From: Laura Gibbons
Sent: 31 May 2019 10:32
To: Planning.Responses
Cc: Simon Davis
Subject: RE: Planning Consultation on: AL/42/19/PL

Engineers Comments Regarding Surface Water Drainage

Description of Works: Construction of a 10 No. bedroom dementia unit on the grounds of Nyton House Care Home. This application affects

G. Proposed storm water mitigation drawing

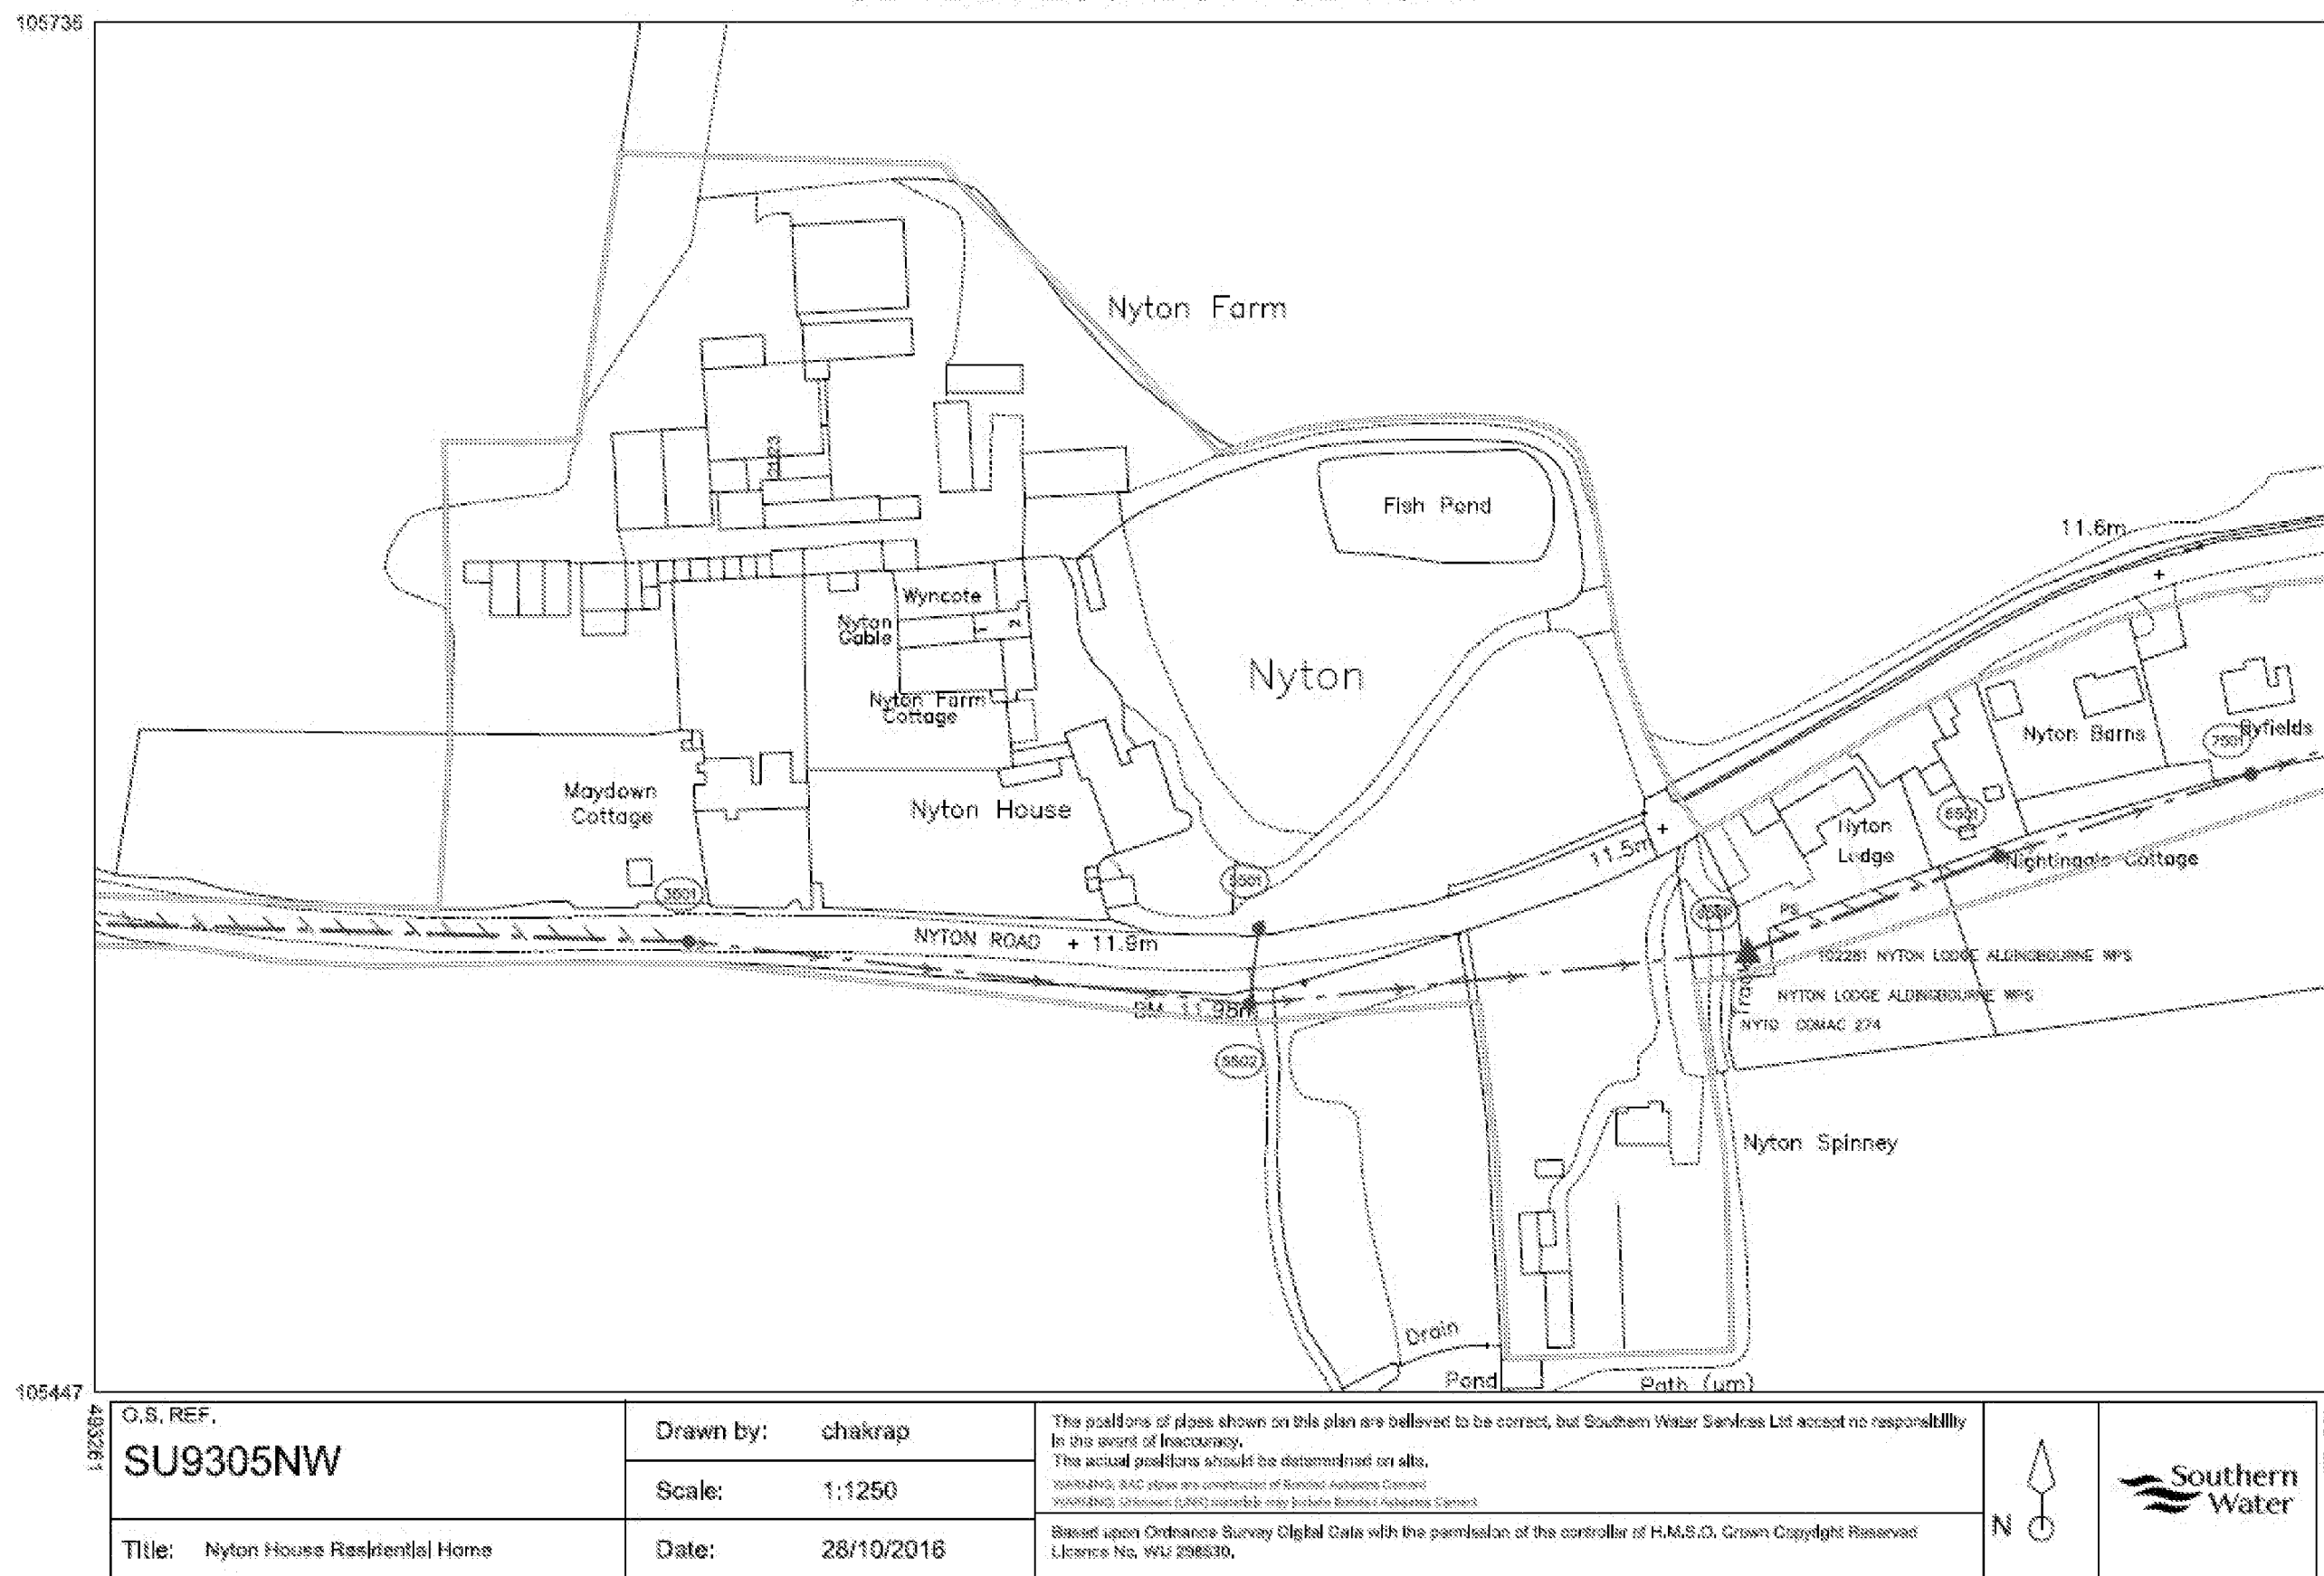
An estimation of the surface water drainage requirements is provided with this application. No testing has been completed on site. It should be noted that it is likely the surface water solution required for this site will need to be formed from a shallower drainage solution, taking up a greater plan area. However, it appears there is space available on site.

If you are minded to approve this application please apply the following conditions to ensure the development is adequately drained now and in the future.

"Development shall not commence, other than works of site survey and investigation, until full details of the proposed surface water drainage scheme have been submitted to and approved in writing by the Local Planning Authority. The design should follow the hierarchy of preference for different types of surface water drainage disposal systems as set out in Approved Document H of the Building Regulations, and the recommendations of the SuDS Manual produced by CIRIA. Winter groundwater monitoring to establish highest annual ground water levels and winter Percolation testing to BRE 365, or similar approved, will be required to support the design of any Infiltration drainage. No building / No part of the extended building shall be occupied until the complete surface water drainage system serving the property has been implemented in accordance with the agreed details and the details so agreed shall be maintained in good working order in perpetuity."
